Engineers Comments Regarding Surface Water Drainage

Application No: BR/128/20/DOC
Registered: 15th June 2020
Site Address: 9 Westloats Lane Bognor Regis PO21 5JZ
Description of Works: Approval of details reserved by condition imposed under BR/219/18/PL for condition 4-surface water drainage; 5-colour schedule of materials & finishes, 6-dustbin enclosures details; 7-electrical vehicle charging points, 8-incorporation of decentralised, renewable, low carbon energy supply system, 9-vehicular access details & 11-cycle parking space details.

Project
 Proposed Site Plan
 Date
 2nd May 2018
 Scale
 1 : 500

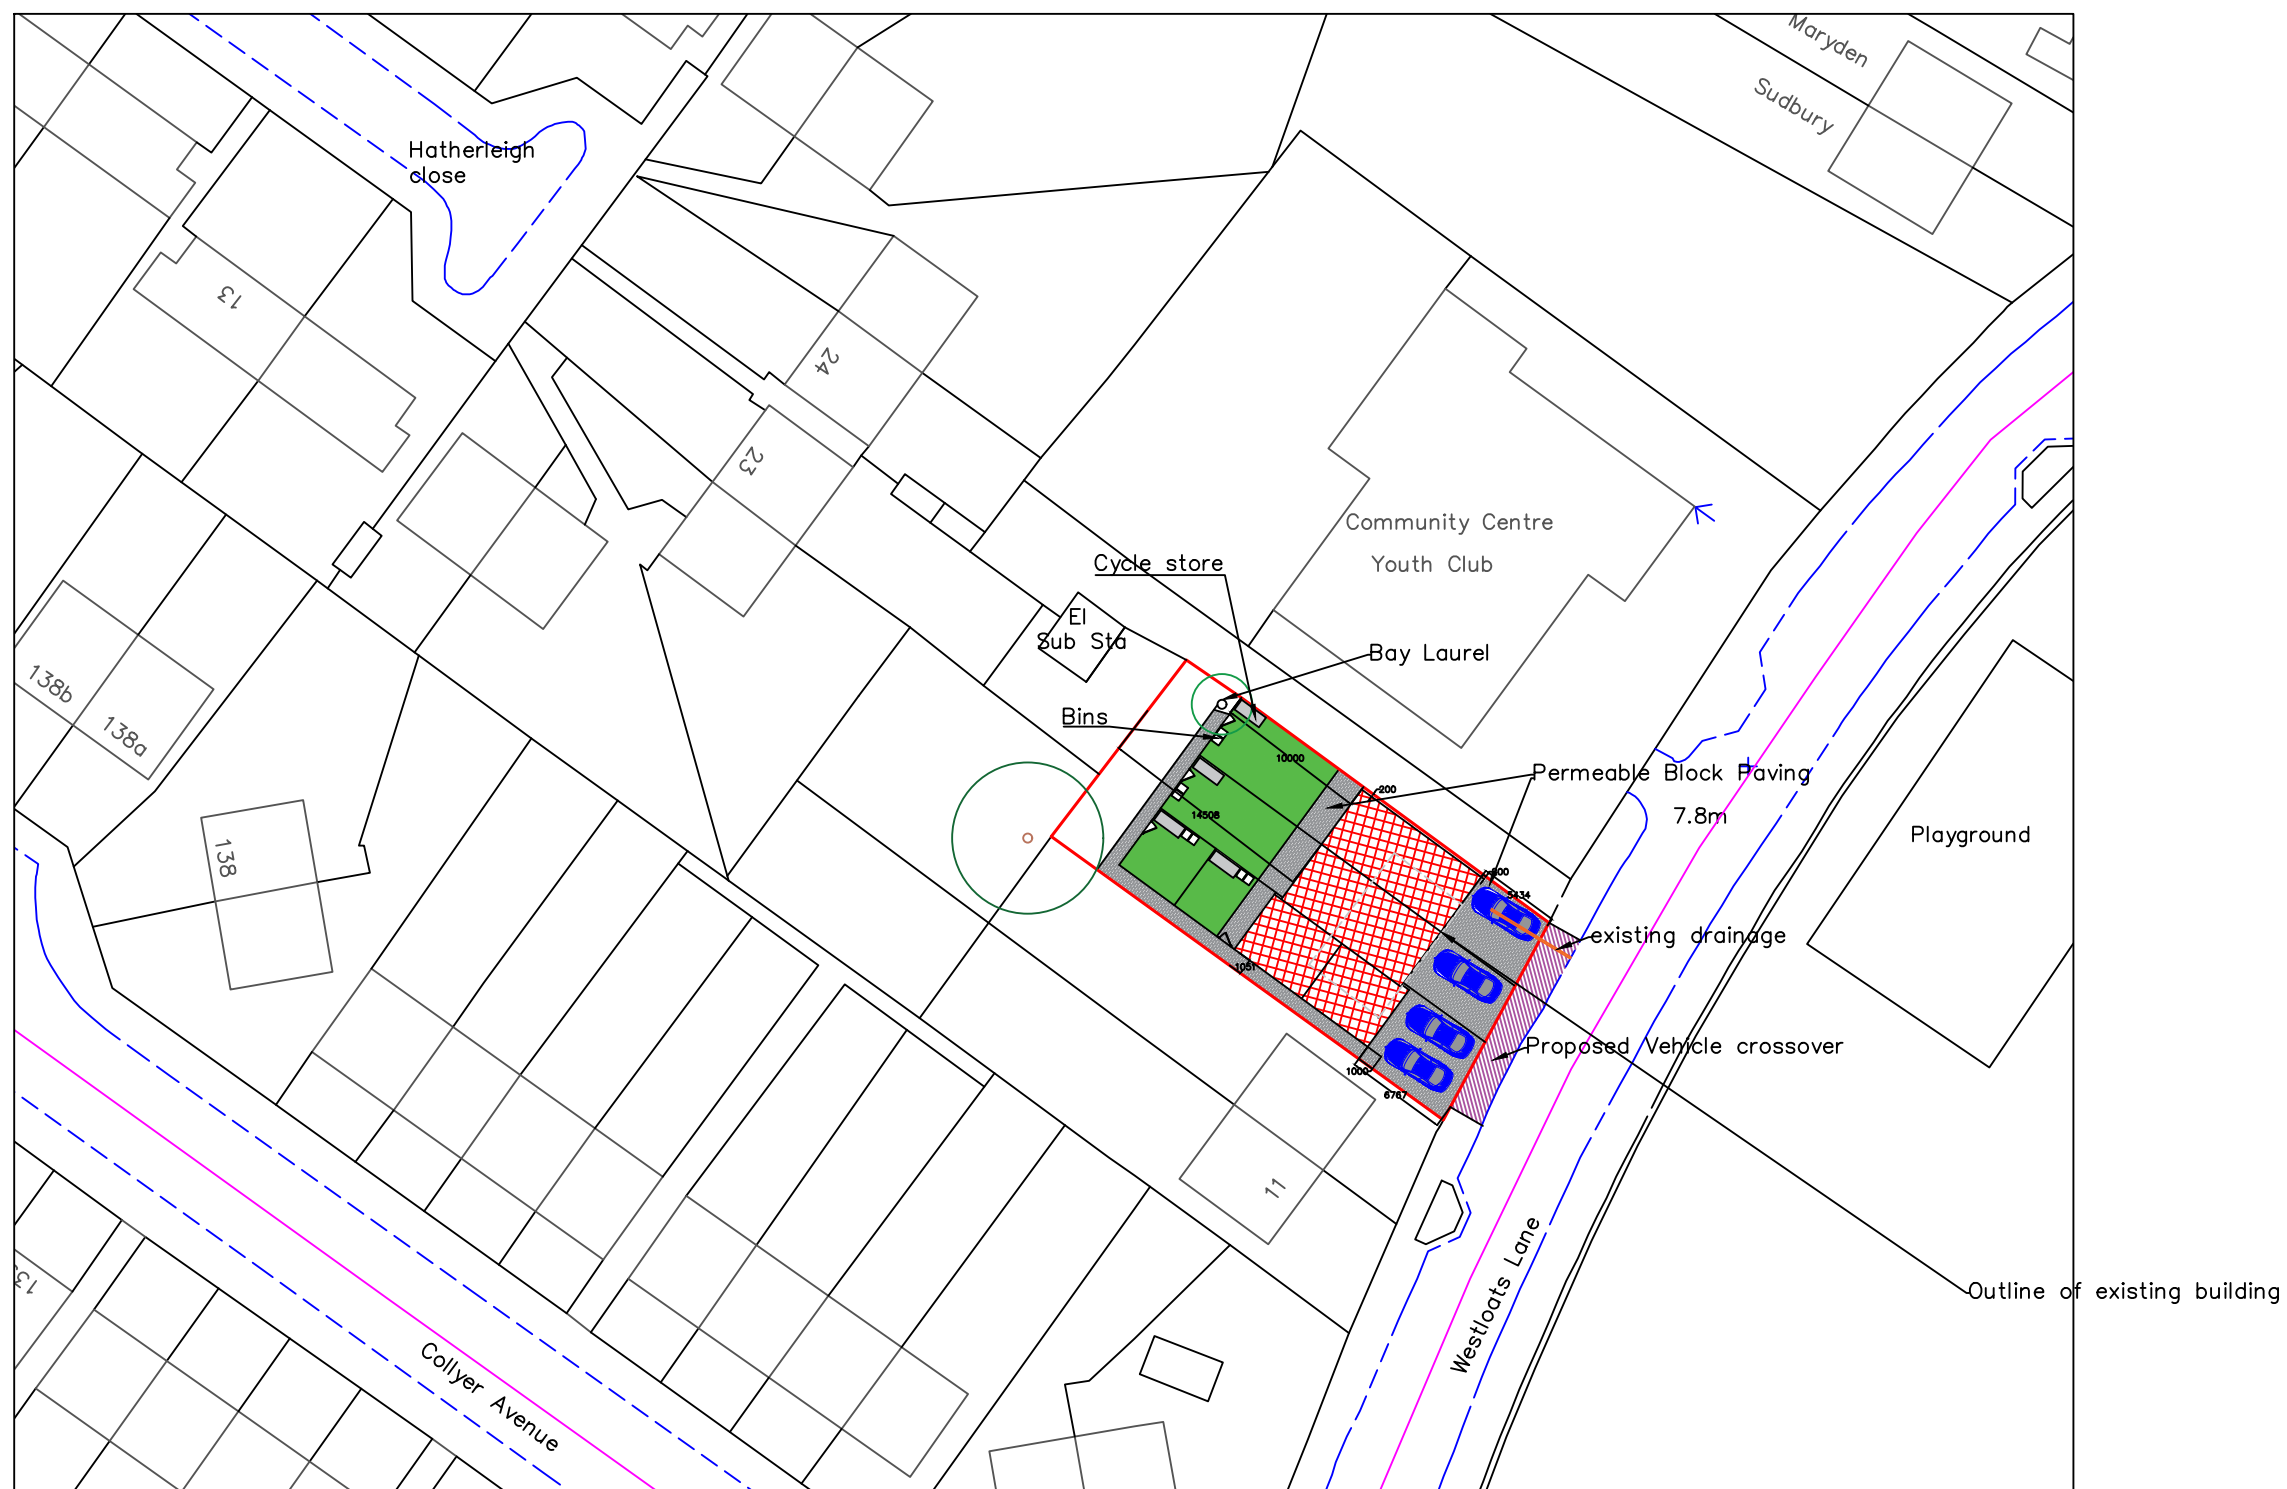
5. No construction detail drawings have been supplied (Soakaway, silt trap, pipe bed and surround minimum).
6. Permeable paving is noted on the site plan, but there are no calculations for this. Nor is it included in the drainage layout. Nor do we have a construction detail for it.

Project Proposed soakaway Plan	Sheet 4
Date 13th May 2020	
Scale 1 : 500

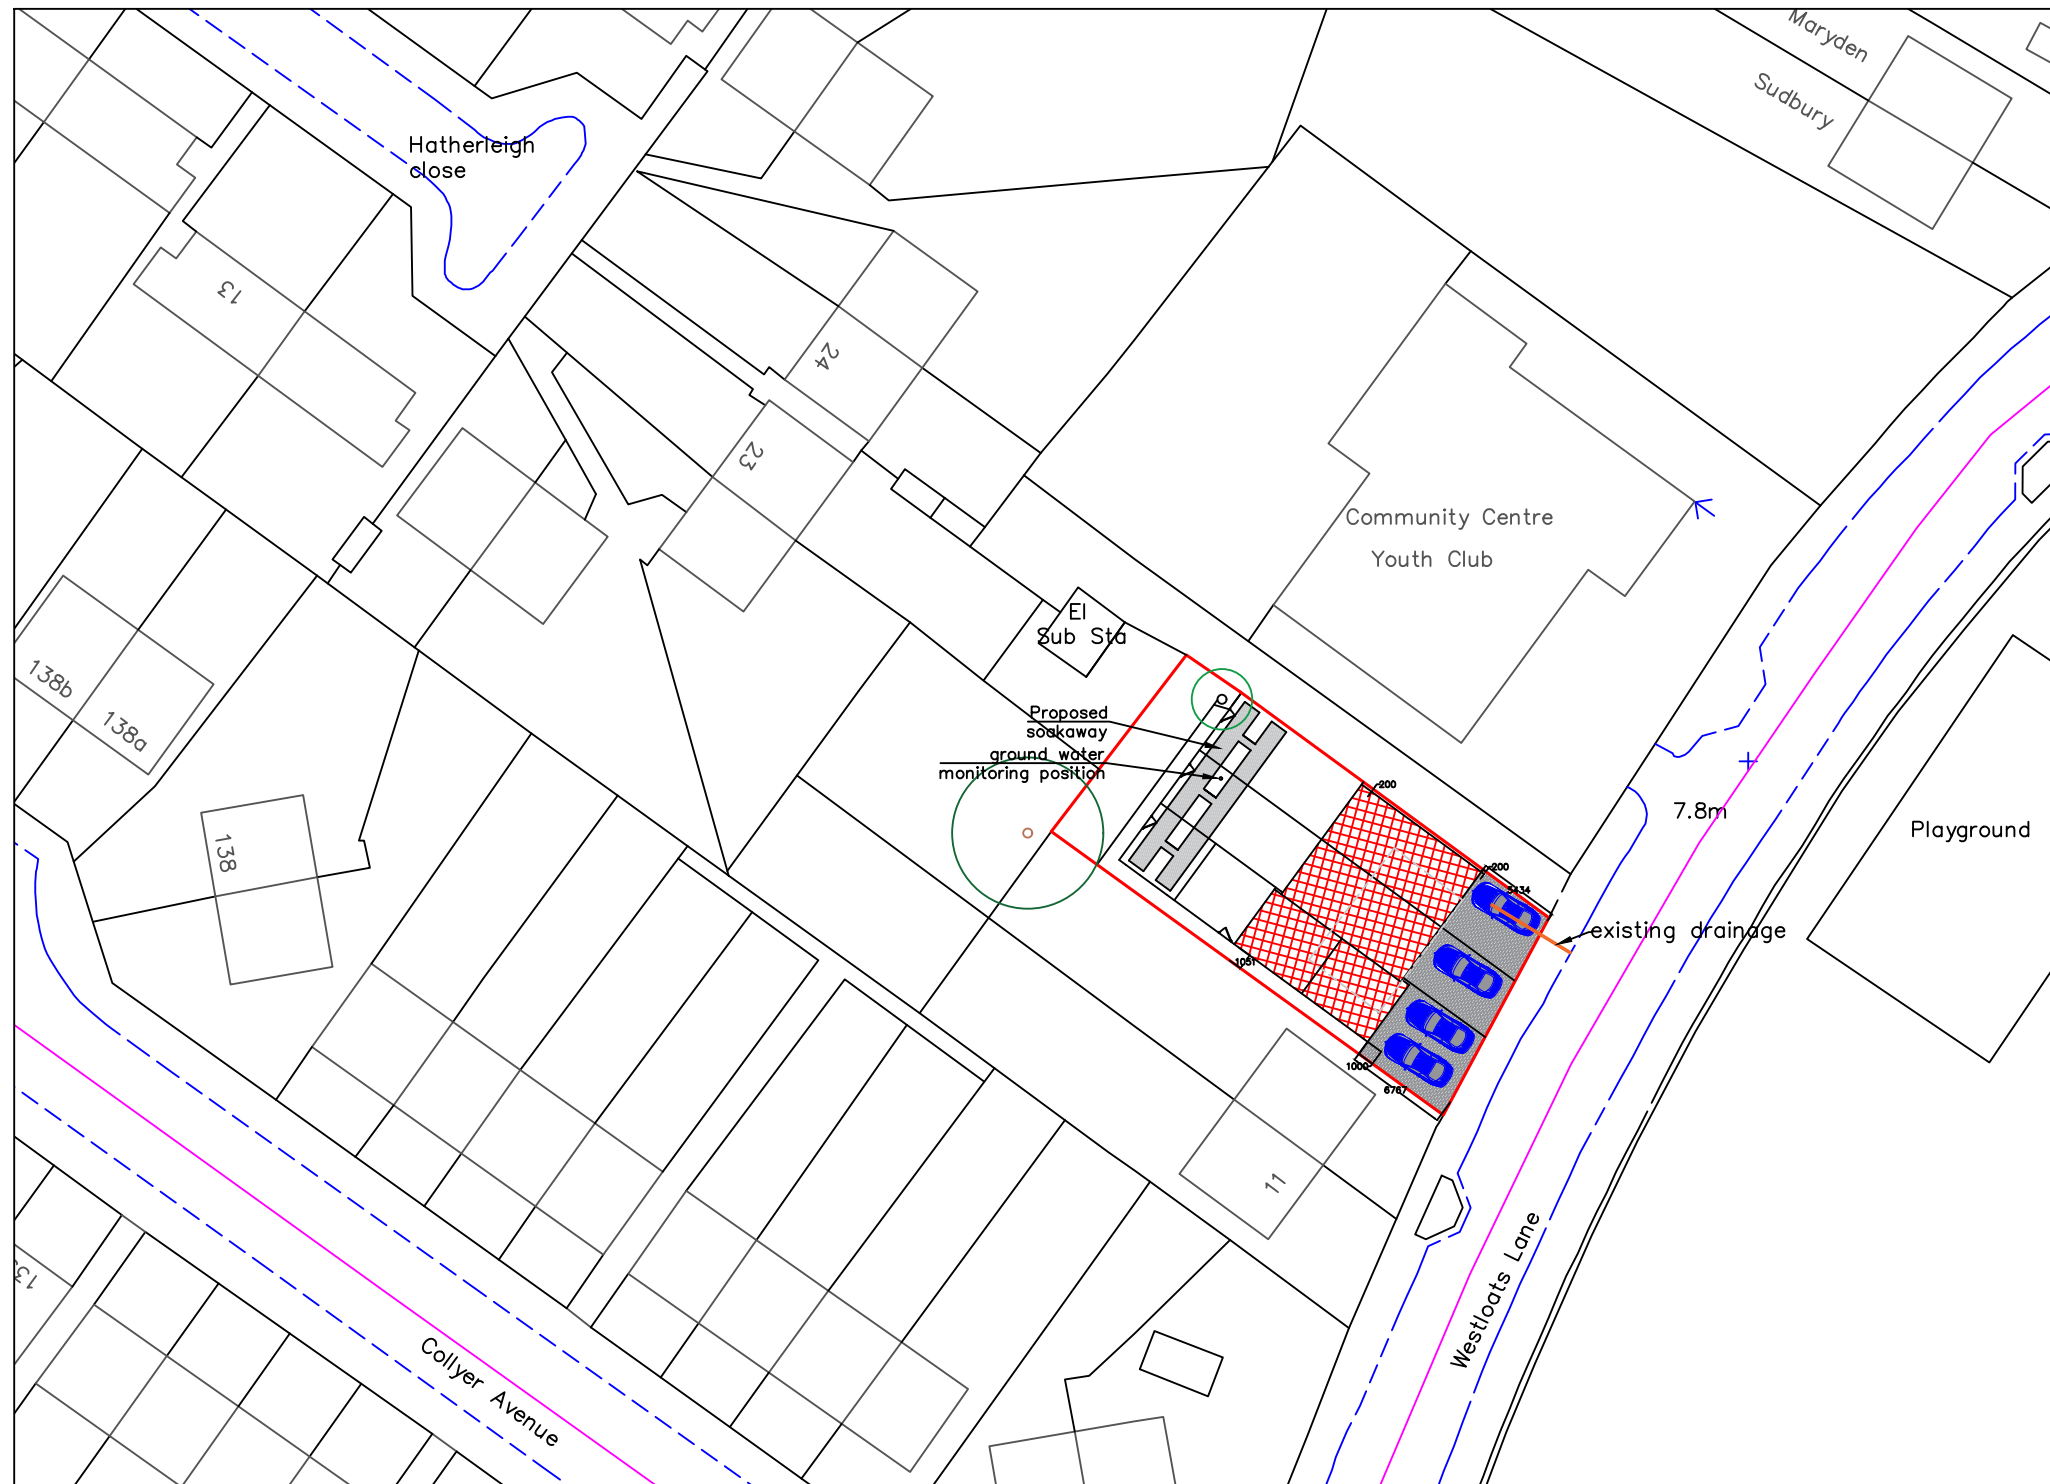
3. Using an infiltration rate of 1.45×10^{-6} the half drain time for a ten year event (+40% climate change) exceeds 24 hours.
4. The Soakaway Plan does not include the necessary level of detail as described in the Drainage Checklist. (Pipes, silt traps/manholes/inspection chambers, invert levels, cover levels, gradients/falls).

7. Any soakaways need to be kept a minimum of 1.5m from the property boundaries.
